From: Amanda Scholes on behalf of Planning.Responses
Sent: 17 April 2018 08:16
To: Planning Scanning
Subject: FW: Planning Consultation on: P/6/17/OUT

Comments from Greenspace

APPLICATION P/6/17/OUT

Site Address: Land North of Hook Lane Pagham

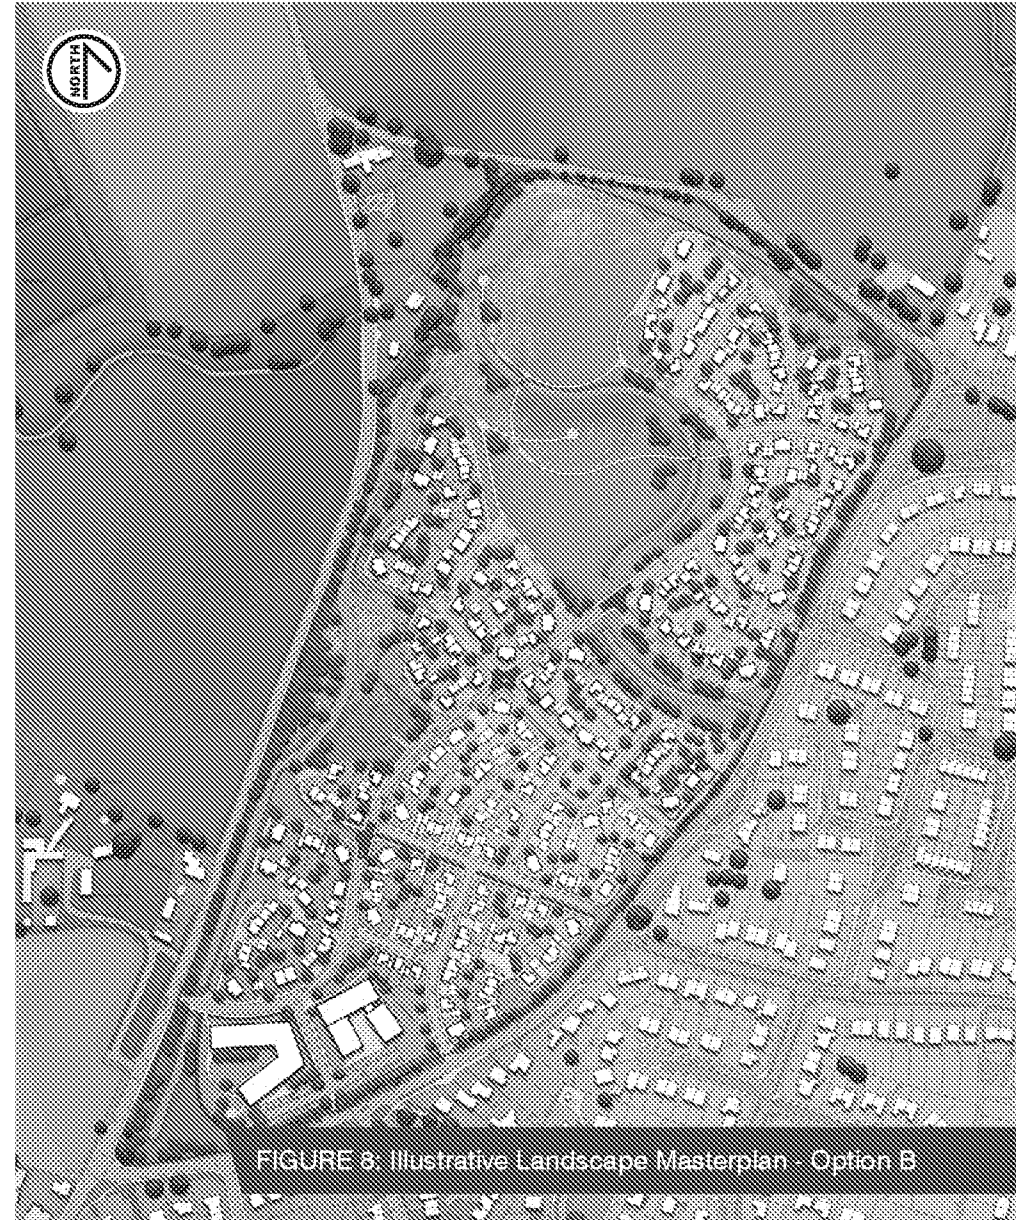
required to assure the adjacent land setting is maintained, the setting is uncompromised and the proposals are appropriate to setting. Indicative buffer zone and hedge enhancements are shown however these also need to be included in plan form detailing the extent of what the enhancements are. Any SUDs areas, would need to be considered in the landscape context if they are included within POS areas as these have the potential to be unusable areas if in time drainage requirements increase, which would limit the available POS space. The landscape proposals will need to make provision for new planting that will subsequently reinforce screening of the site, improve biodiversity and enhance the landscape character of the site and its surroundings and that are subsequently considered to fully comply with Saved Policies GEN27 and GEN 28 and emerging Arun Local Plan Policies.
